Submissions Report

Modification to the Picton Regional Sewerage
Scheme

November 2012

Figure 2 New growth areas

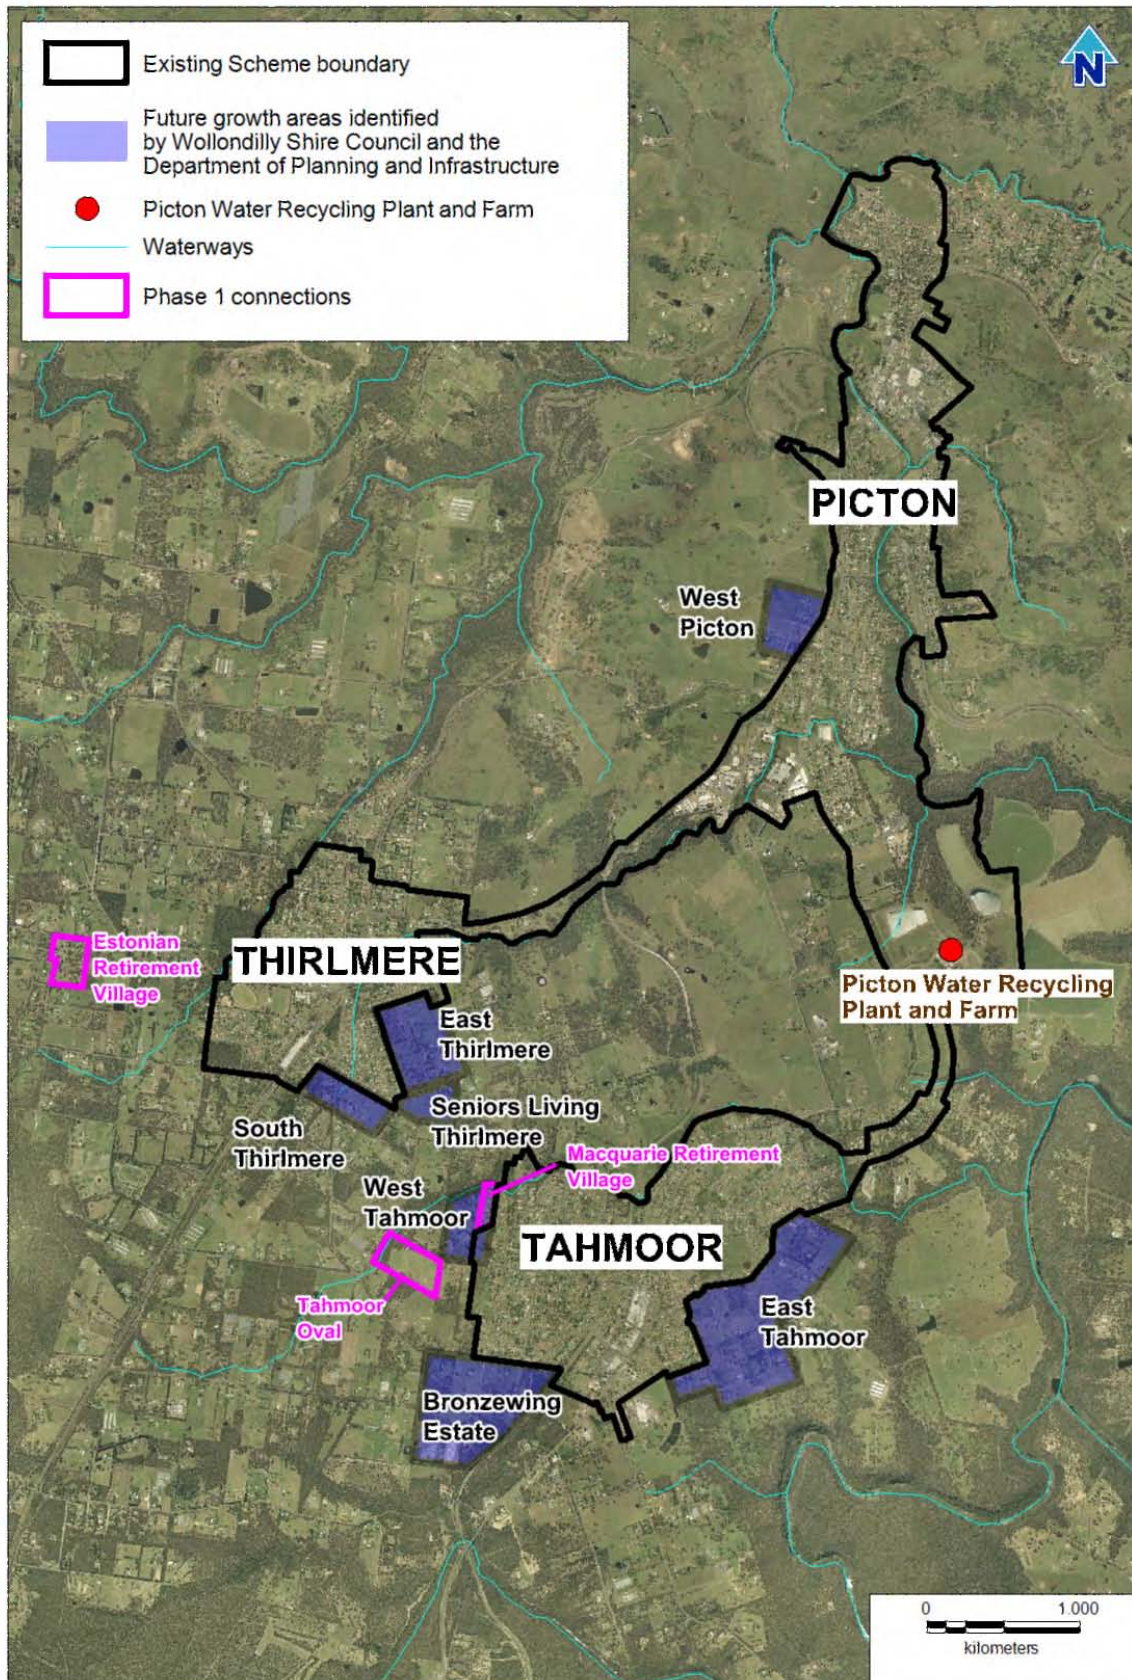
- requests for more flexibility in the areas that could be serviced by the Picton Sewerage Scheme and requests for specific connections (5),
- concerns were raised about the capacity of the existing irrigation area/ discharge to the environment (5),
- minimising the impacts of noise and vibration and visual amenity (1),
- potential flora and fauna impacts (1),
- notifying residents of construction works (1),
- water reuse (1),
- identifying other approvals that may be required (3), and
- advice was also provided on the need to amend the locations of the growth areas shown in Figures 2-5 of the Assessment Report (1).

Figures 3 – 5 from the Assessment Report have been updated in **Section 3.4** of this report to show the latest growth areas provided by Council and removal of the Scheme boundary.
